HINCKLEY NATIONAL RAIL FREIGHT INTERCHANGE

Project reference TR050007

Applicant's response to Deadline 6 Submissions [part 2 - HBBC]

Hinckley & Bosworth Borough Council

Accessibility Plan Cyclist Routes - Point 1 to Point X

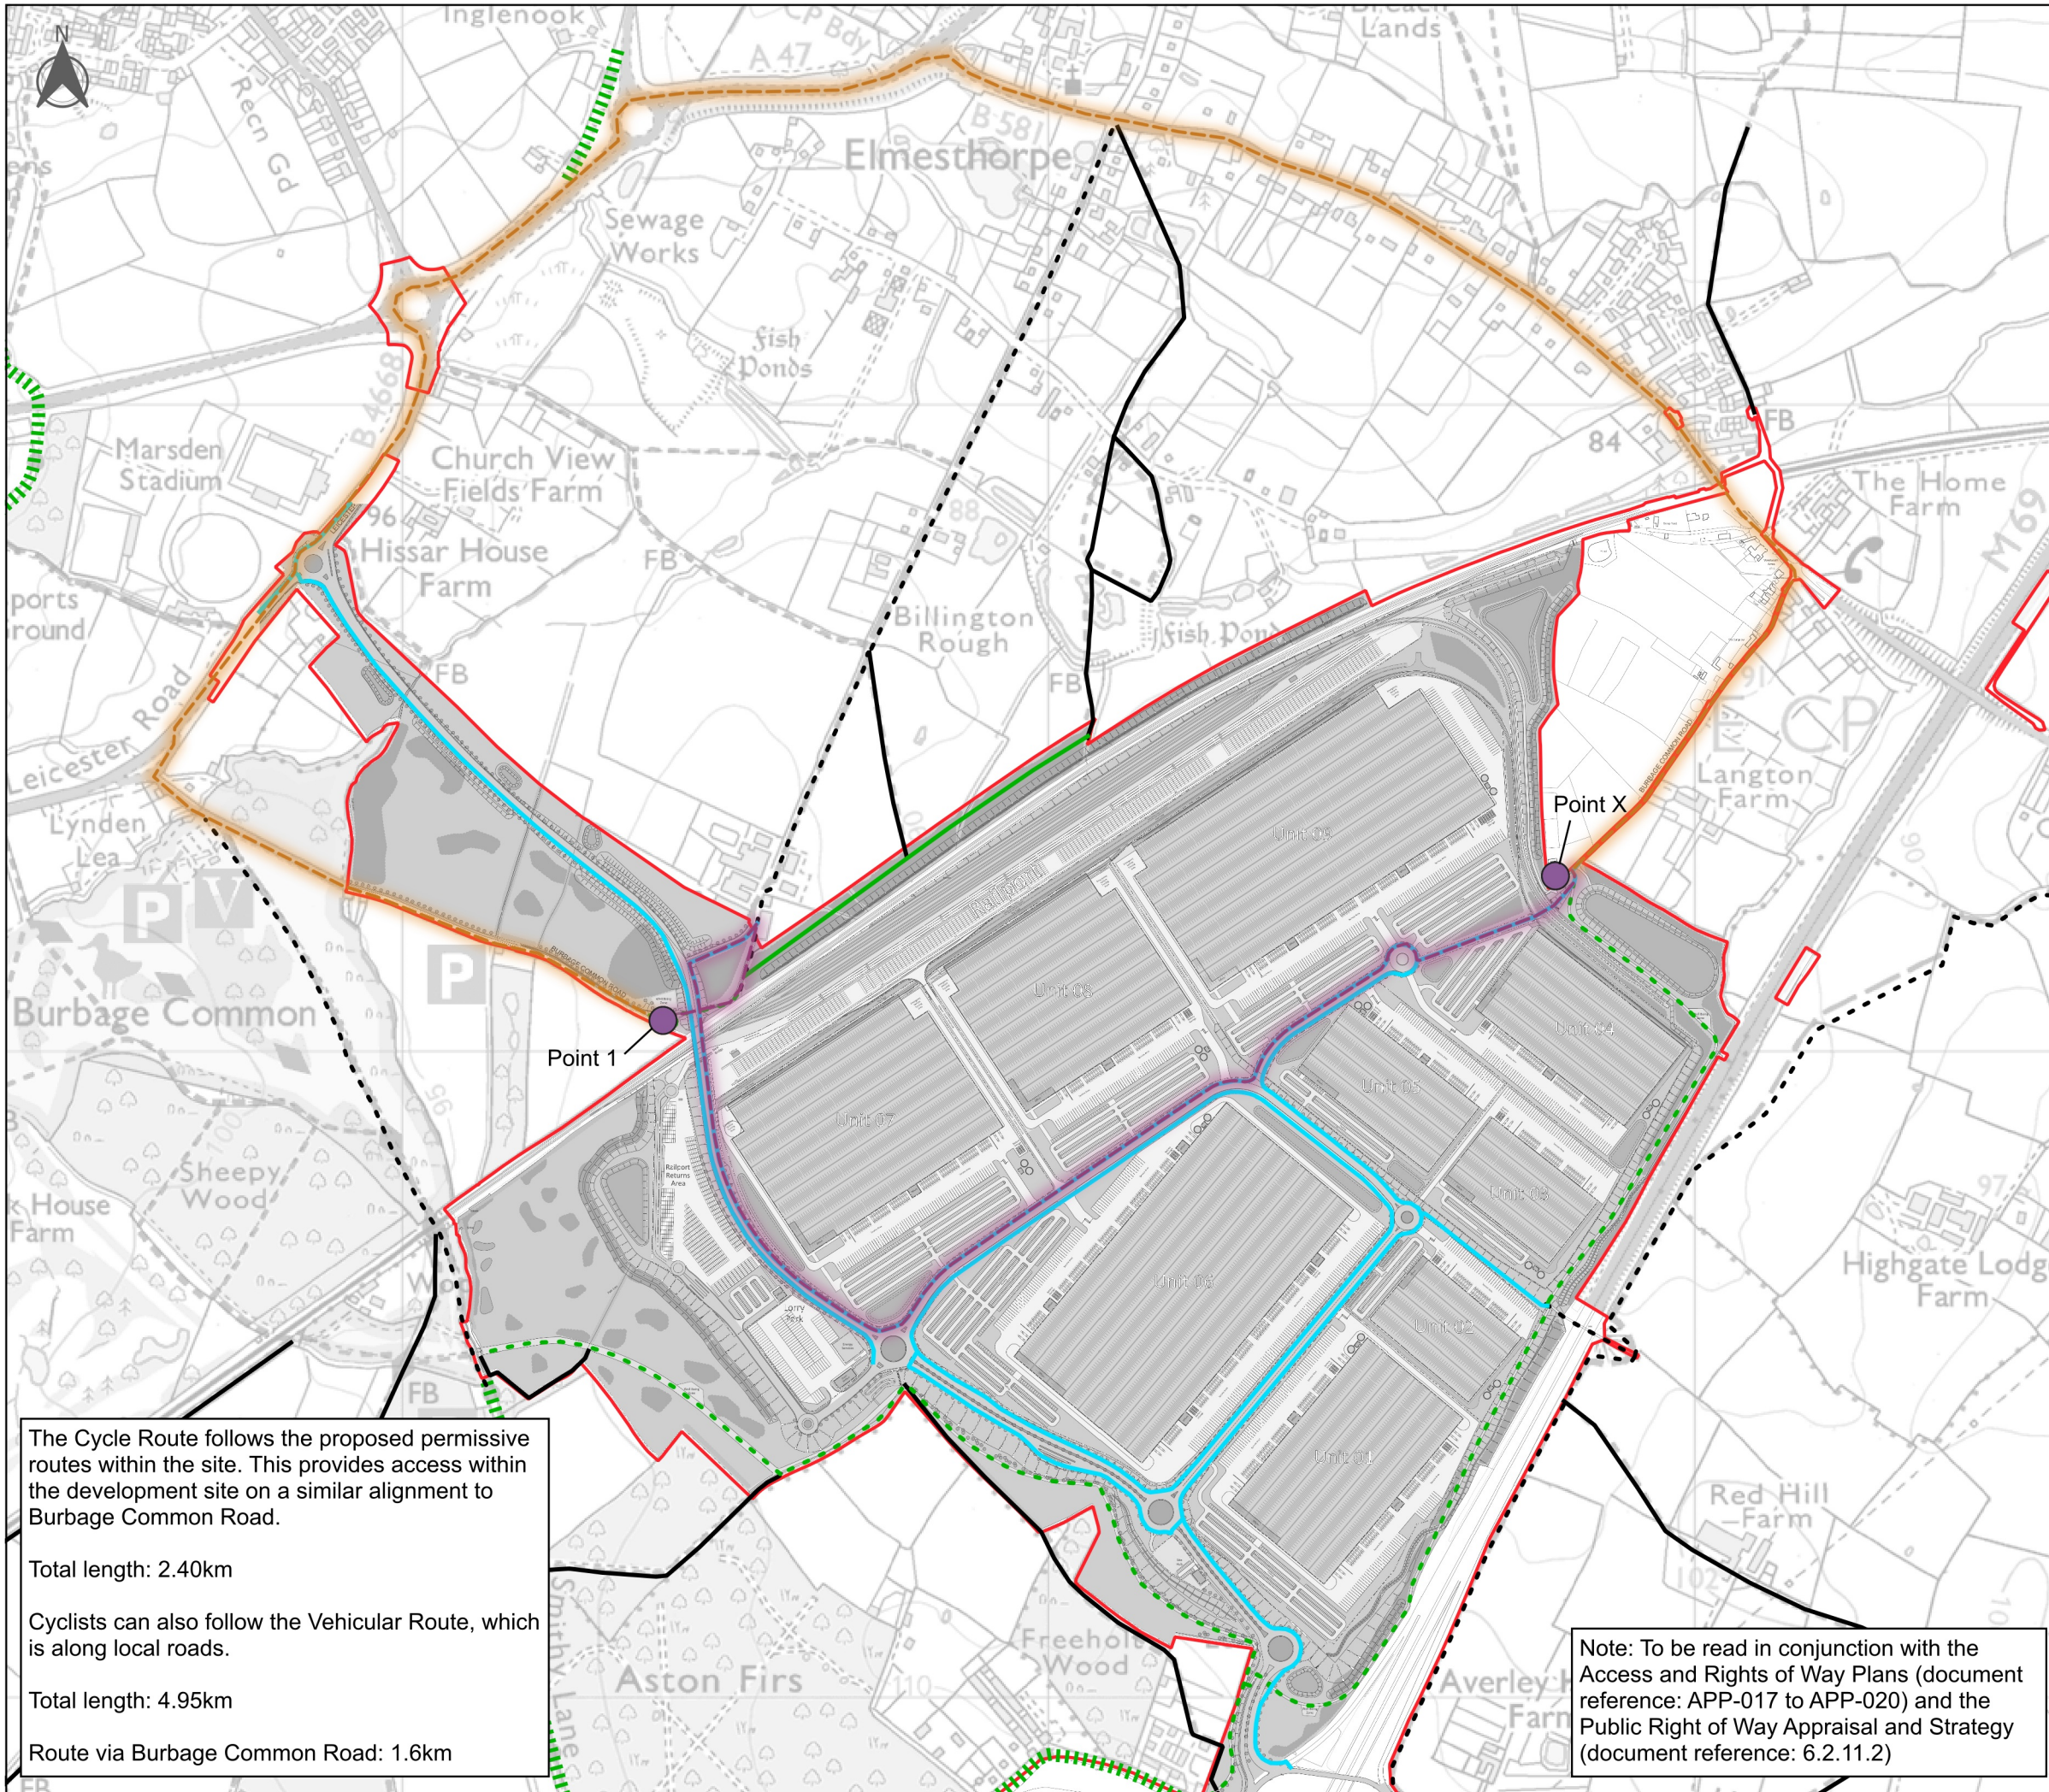
8.14 and extract plan 2.32	The Council has stated before that the routes shown without enhancement do not demonstrate 'good cycle access to the site' and safe high-quality routes to most of Hinckley are not shown. Consequently enhancements as requested are required	The routes shown on the extract plan referenced to the north of the development link to off road facilities along the B4668 and A47 and on to Hinckley, Barwell and Earl Shilton via routes shown on the <i>Choose How You Move</i> interactive cycling maps for the area (extract below).

The routes to the south of the development link to the B4669 and on the Burbage. Enhancements to these routes have been identified through the STS (document reference: 6.2.8.1E) and those to be delivered will provide a better link to Burbage and the south of Hinckley, including the railway station from the south of the development through provision of off carriageway footway/cycleway and a better link to Barwell and Earl Shilton to the north of the development through provision of a toucan crossing on the A47 and additional off carriageway footway/cycleway. It is important to note that these enhancements are not required to achieve the modal shift set out in the STS (document reference: 6.2.8.1E) and are therefore provided to encourage more people to cycle who otherwise would not do so.
